DESIGNERS RESPONSE

Proposed Residential Development – Fernside Avenue, Huddersfield

ON BEHALF OF
TH3M Architects

The proposals have now been subject to a Stage 1 Road Safety Audit dated February 2019 carried out by Optima Highways. The 'Problems' and Recommendations' from that RSA are included in this Designer's Response report for ease of reference.

SCALE: 1:250 @A3
 DATE: FEB 2019
 DRAWING NO: 1901502

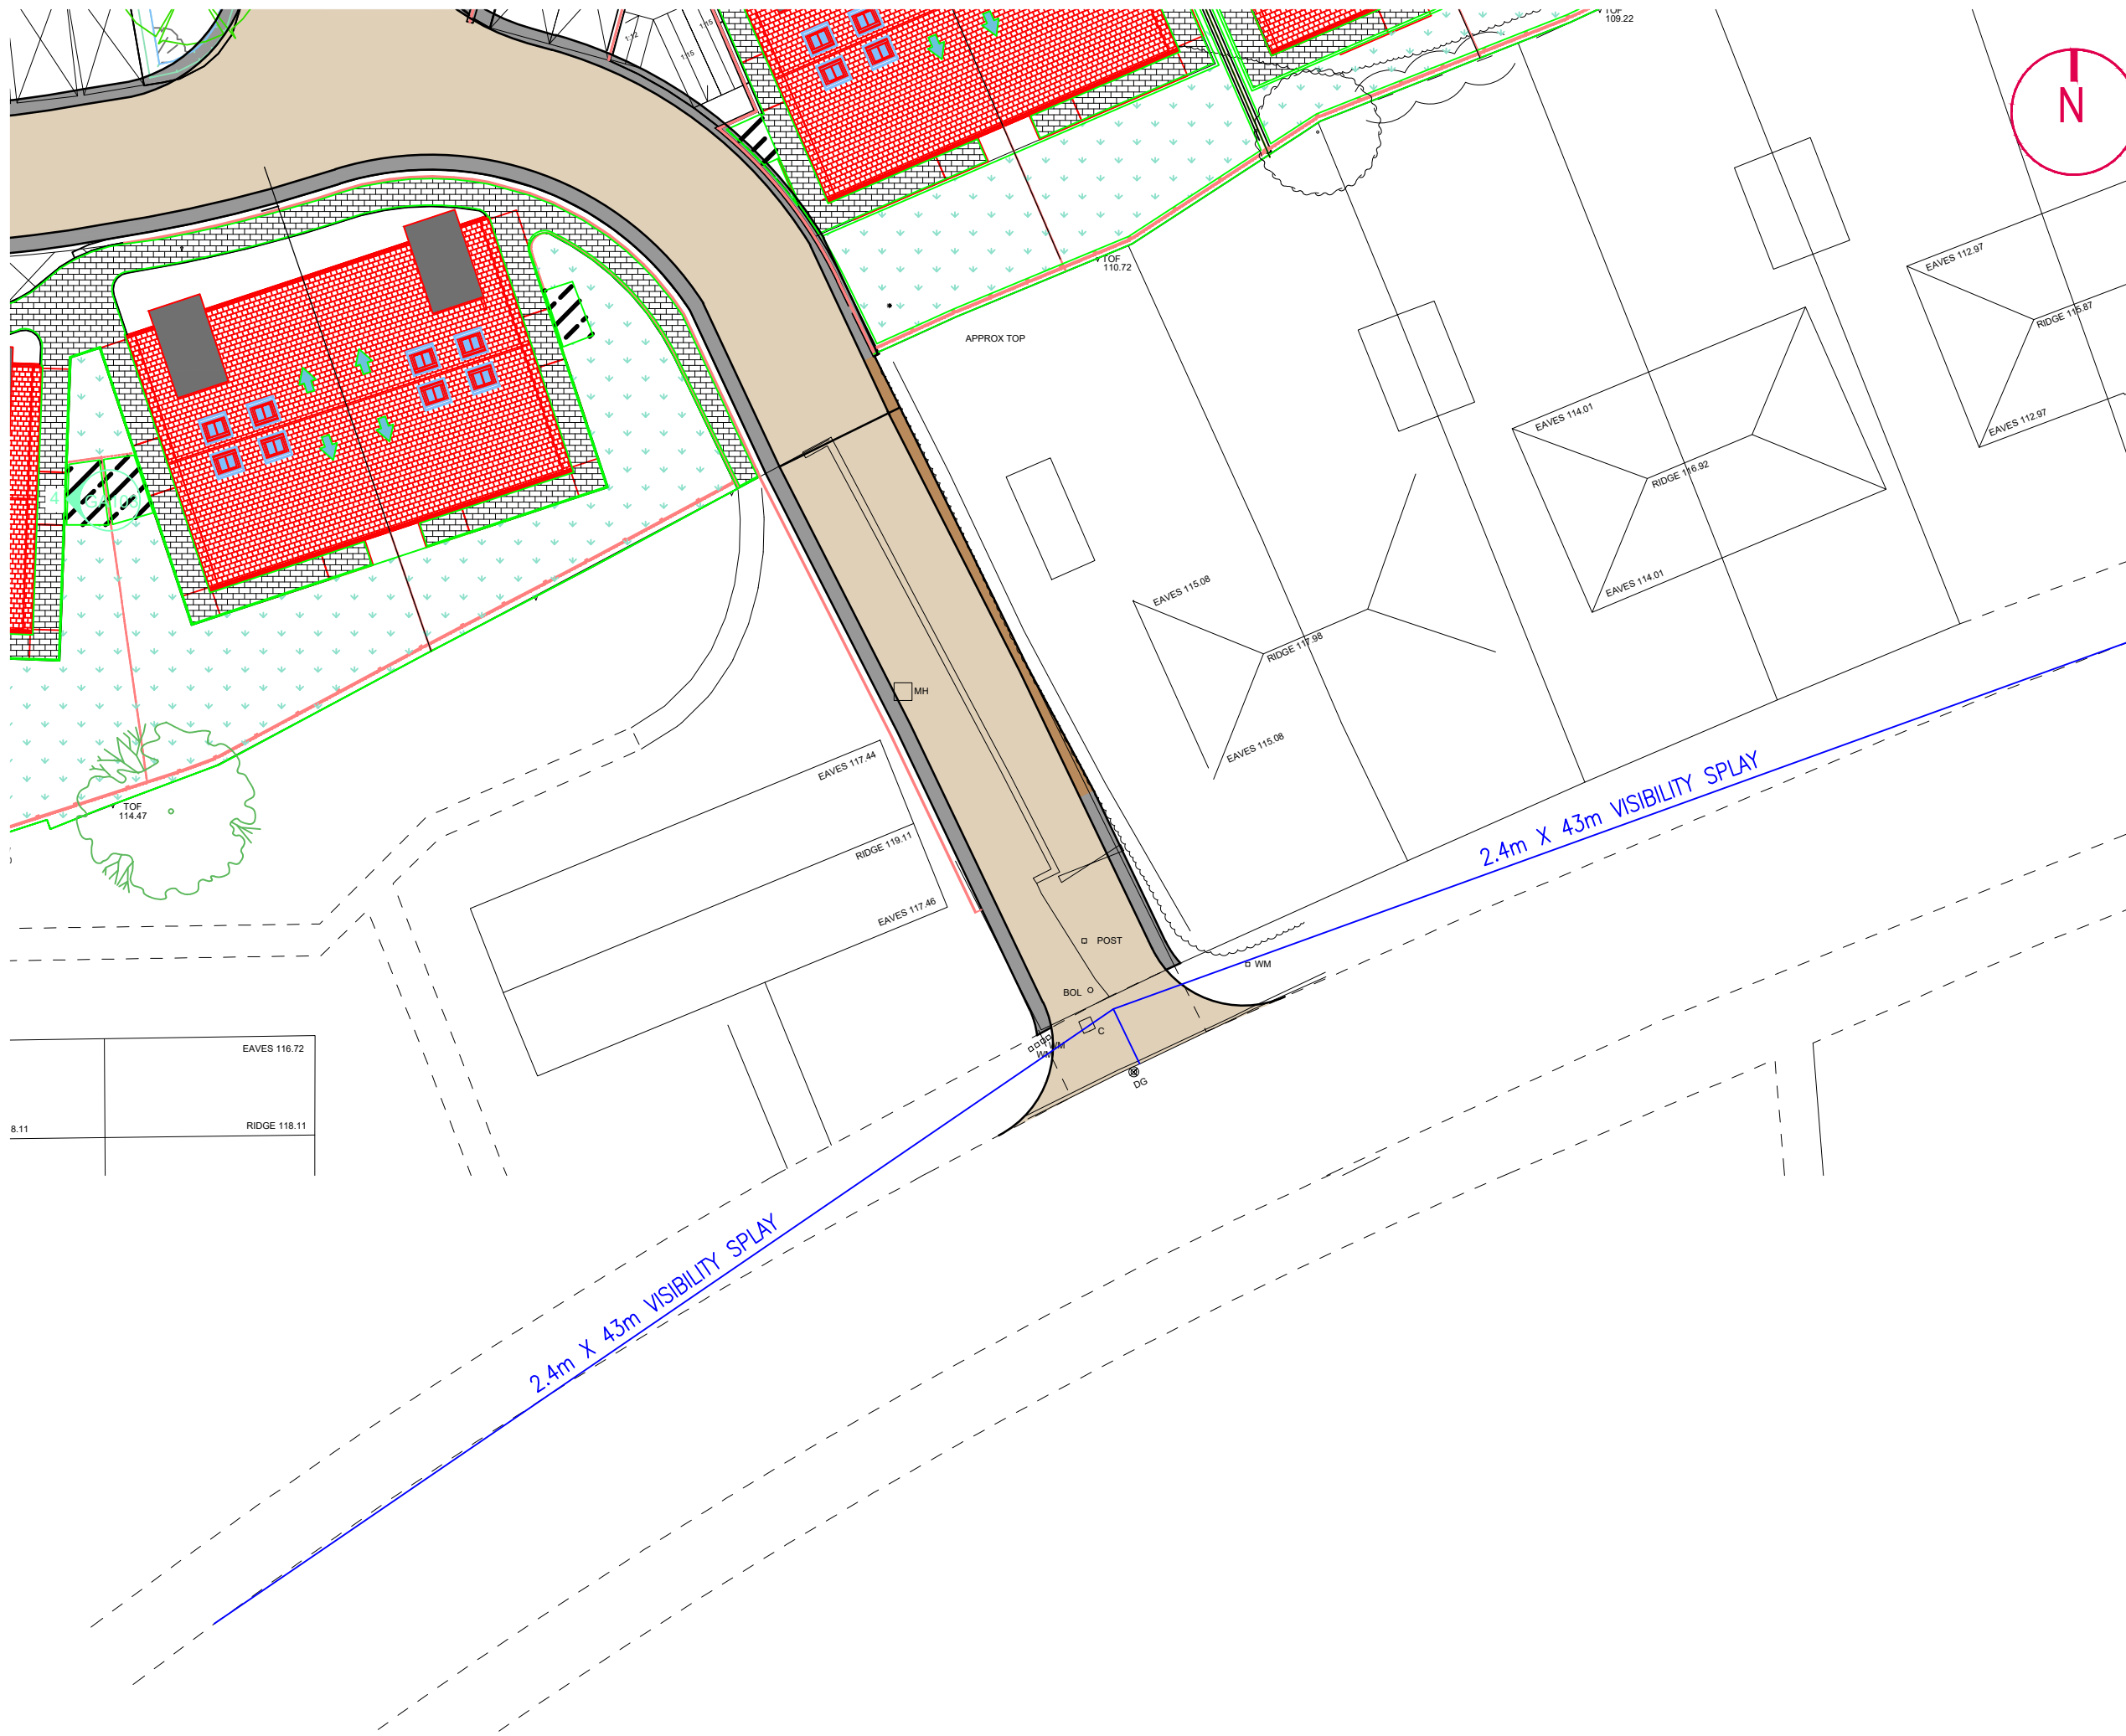
Problem: Proposed Pedestrian Link

Location: To the rear of existing dwellings along Fernside Avenue

Summary: *The gradient of the pedestrian link could contribute to pedestrian slip/trip accidents in icy conditions.*

It is recommended that the design of the pedestrian link minimises the gradient, crossfall is provided east to west and the requirement for a fence/barrier is reviewed at the detailed design stage.

Recommendation accepted – A review of the pedestrian link will be undertaken at the detailed design stage.
